Response to Submissions

Prepared for: **Grand Noble Project 1 Pty Ltd**

The State Significant Development Application (SSD-96272465) for residential development with in-fill affordable housing at 11–23 Rangers Avenue, Mosman was publicly exhibited between 4 December 2025 and 17 December 2025. During the exhibition period, a total of 185 submissions were received.

01. Shadow Proposed 12pm June 21

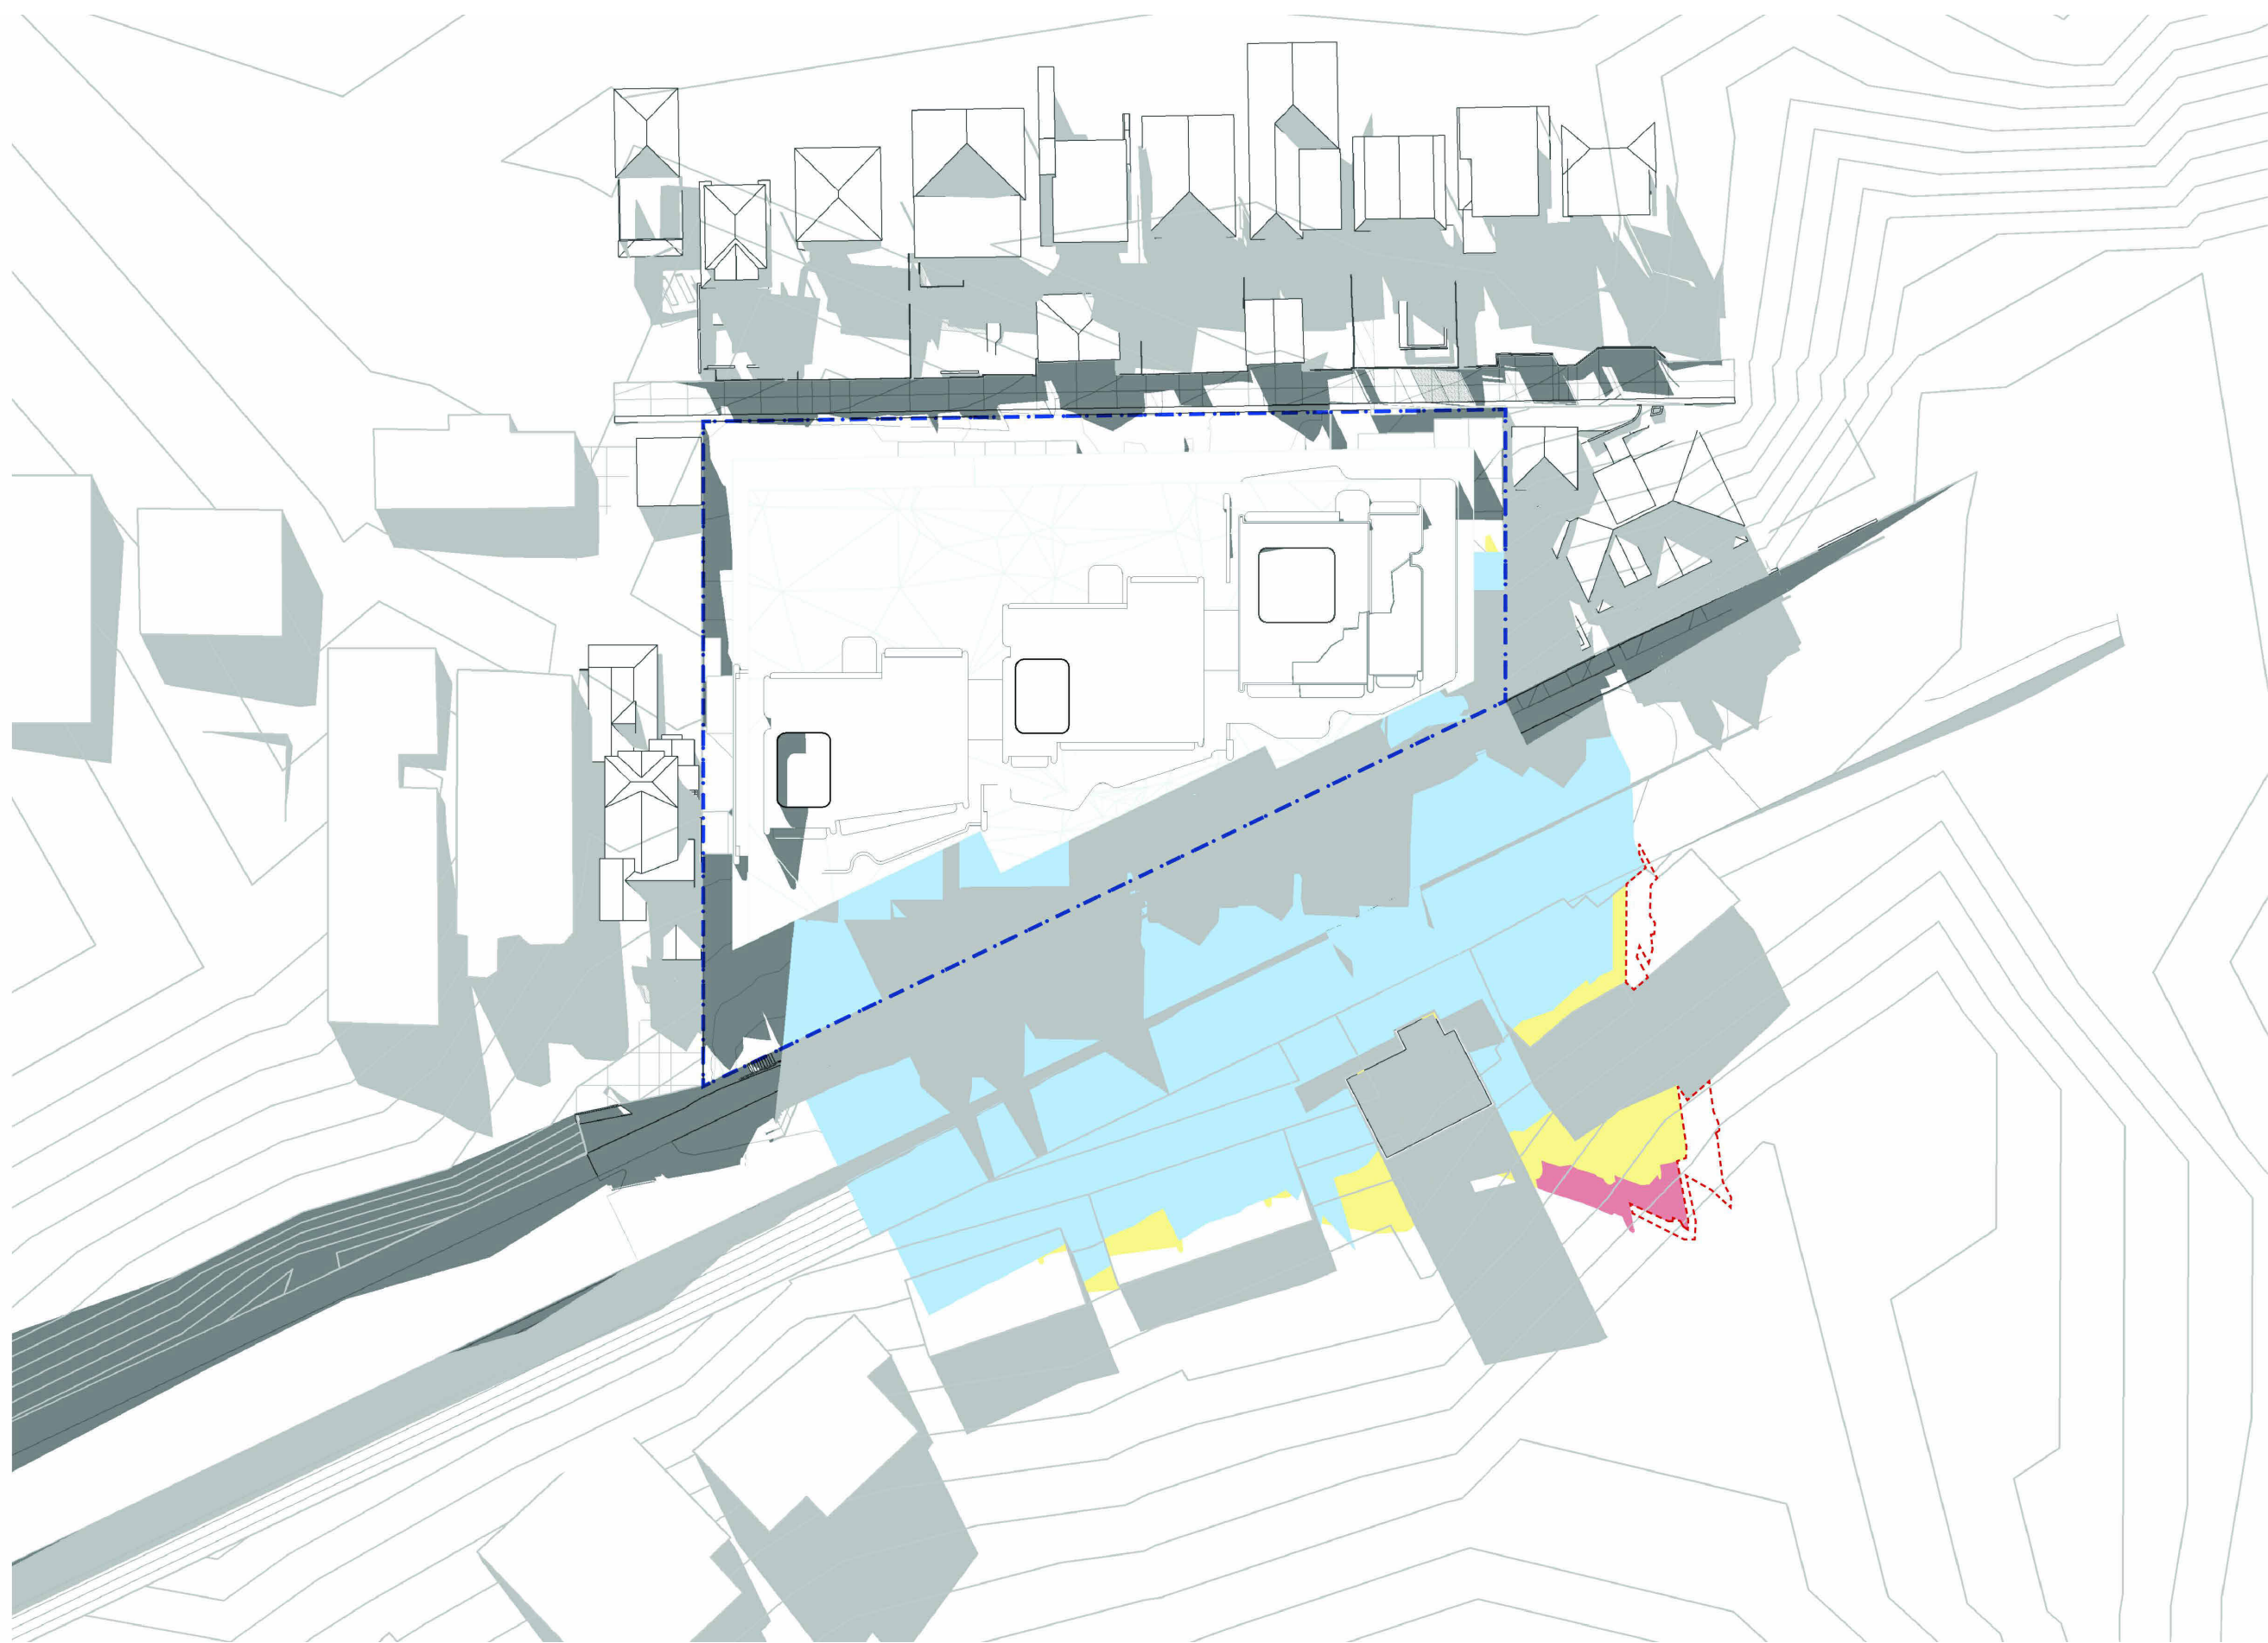
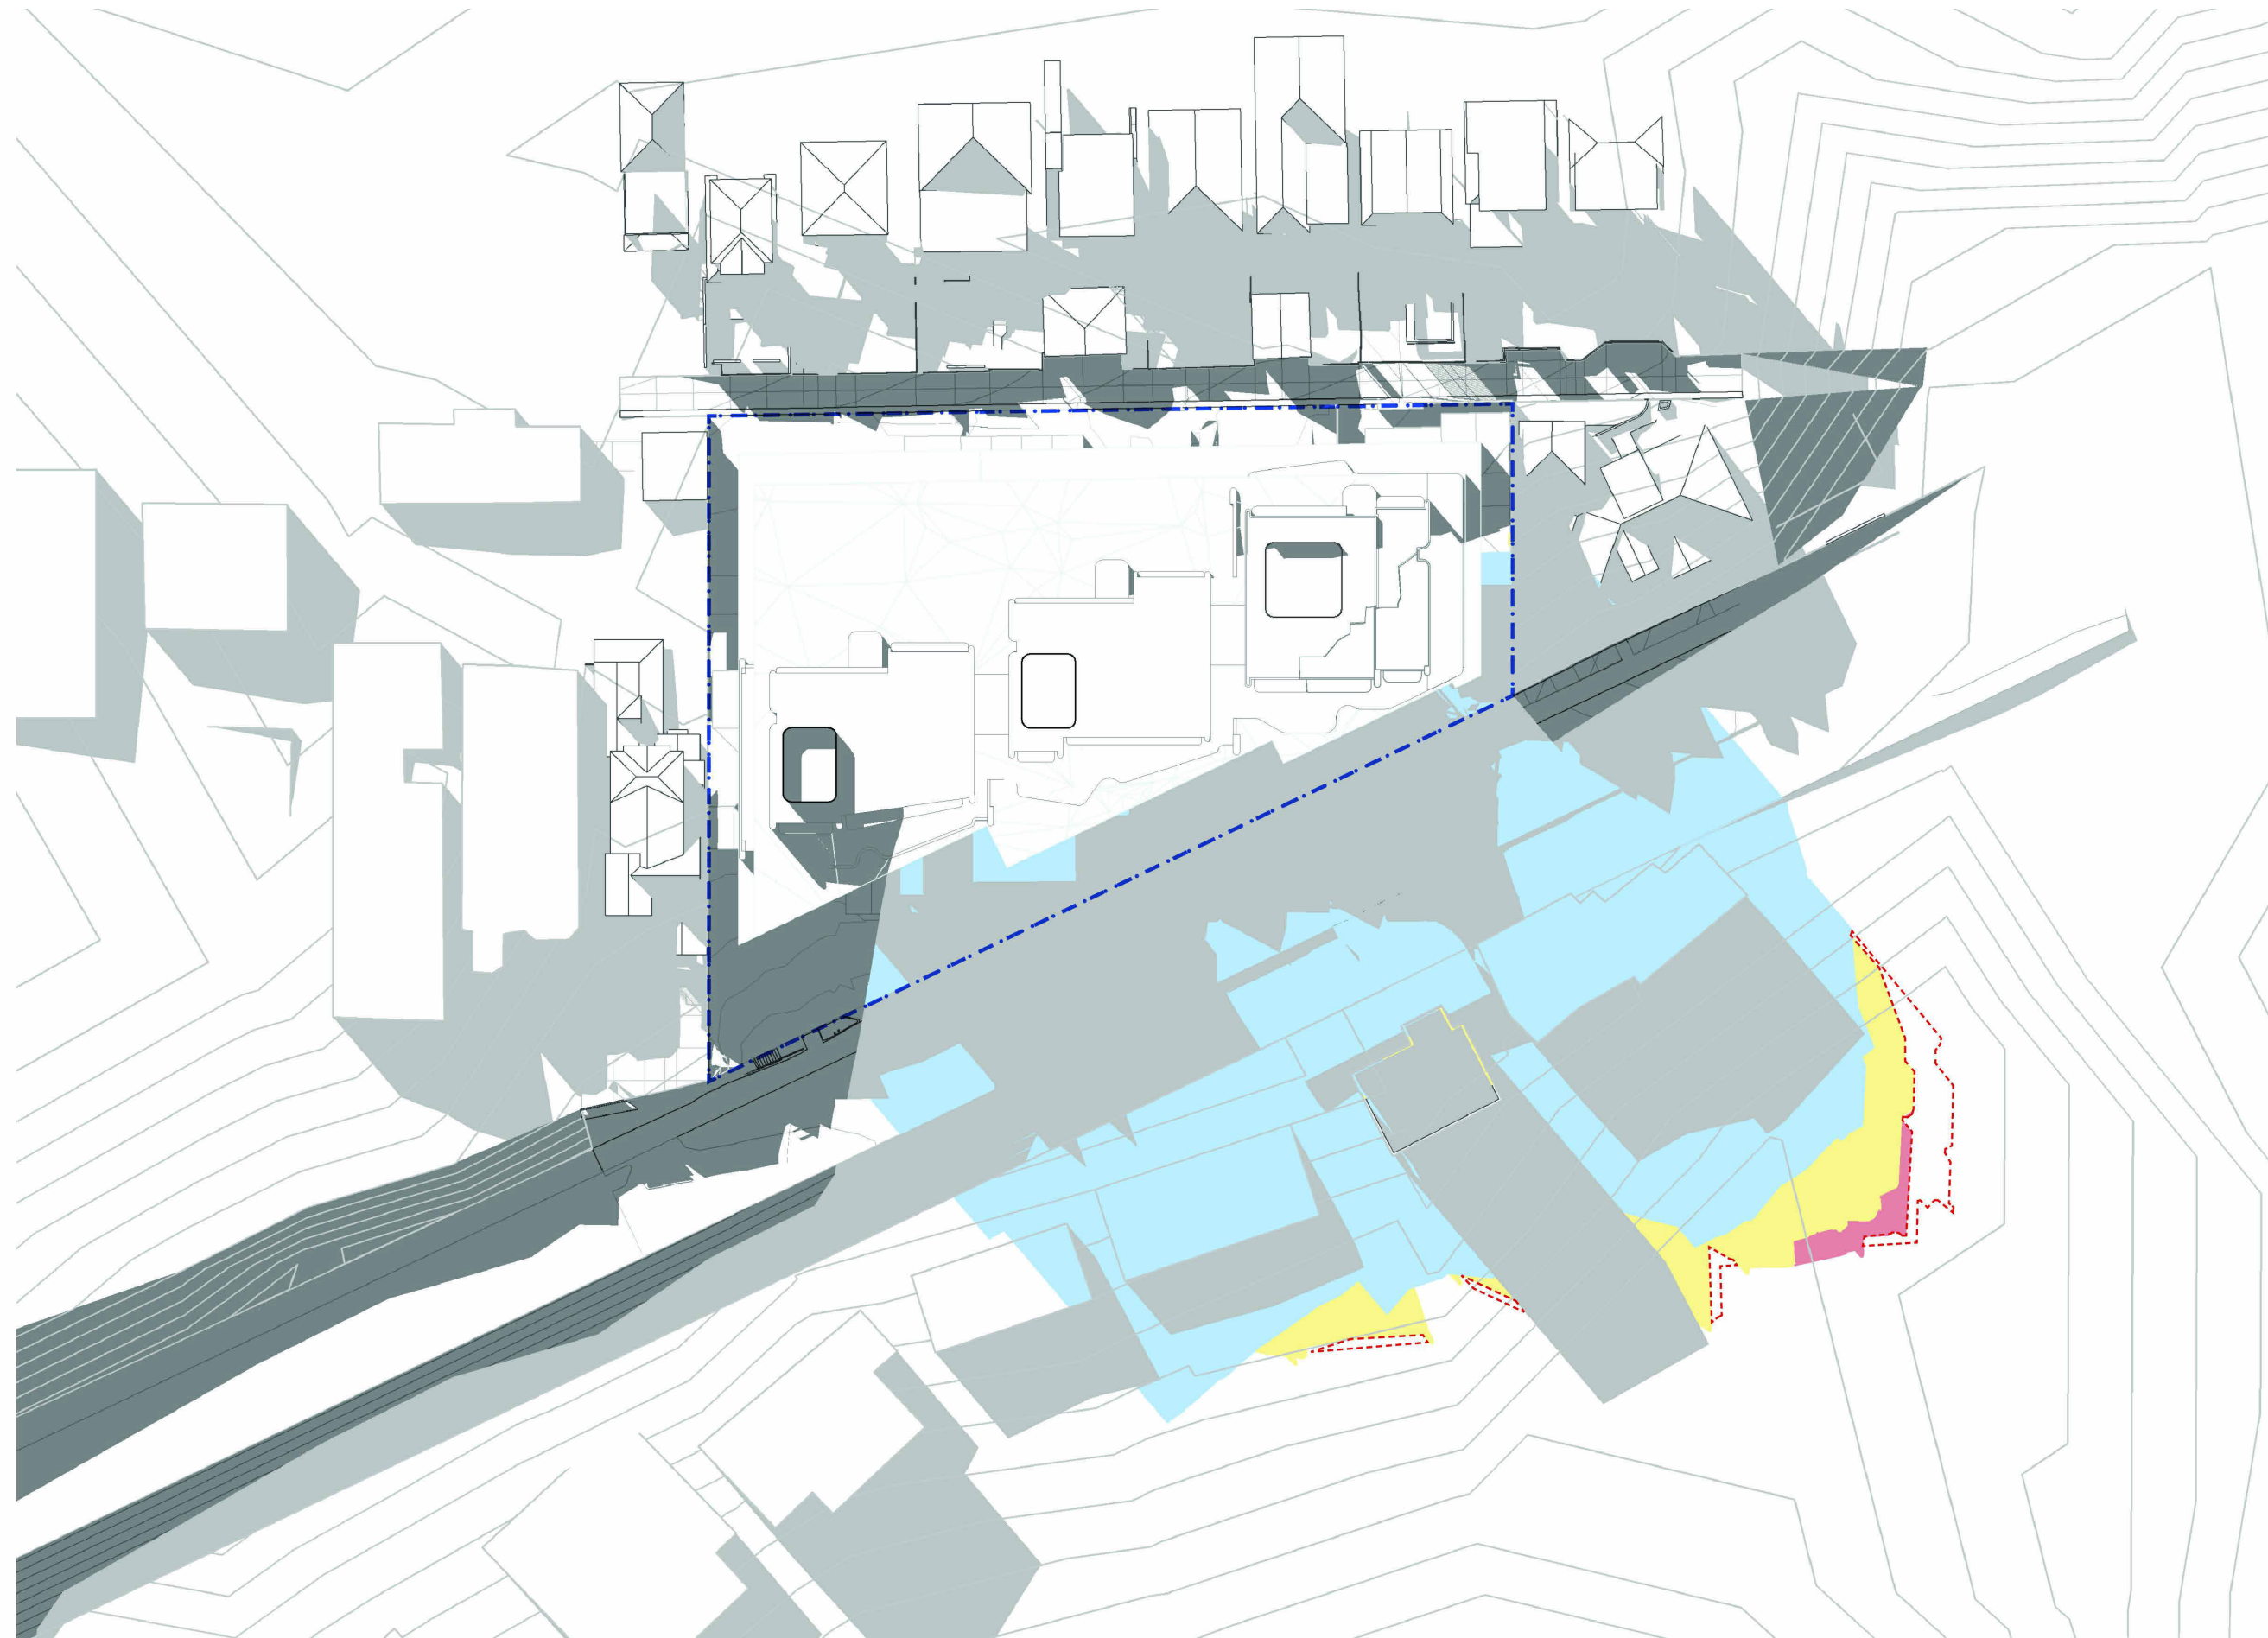
- Raises concerns regarding view sharing and amenity impacts, stating the proposal prioritises views from within the development, fails to demonstrate minimisation of view loss to surrounding properties, provides inadequate separation and transitions, and may worsen already constrained solar access south of Rangers Avenue.
